**Epping to Thornleigh Third Track Proposal.** Application number SSI 5132.

I/we object to the Epping to Thornleigh Third Track Proposal and consider that the EIS is inadequate and does not address the full impact of this proposal. It will cause untold damage to the health of residents and to the fabric of the Beecroft Cheltenham Heritage Conservation Area. Do not approve this project, reconsider the alternatives and protect the community.

Figure S.5 Artist's impression of new elevated concourse at Cheltenham Station looking south from The Crescent (indicated by dot)

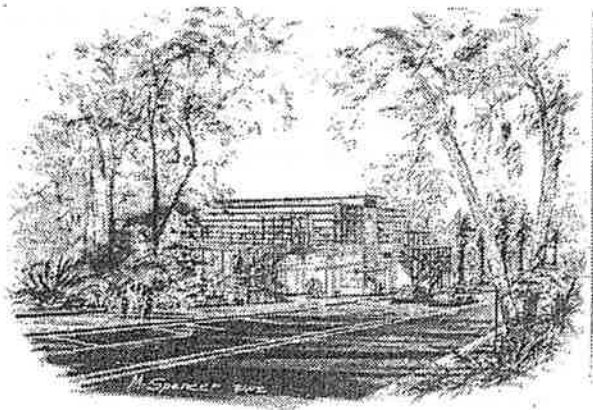
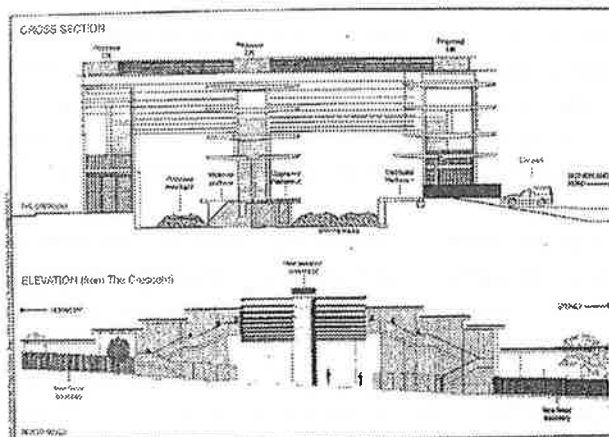
- The proposed redevelopment of Cheltenham Station shows no regard for the HCA. The visual impact of the proposed 13m high glass and steel concourse is totally unacceptable in this HCA.
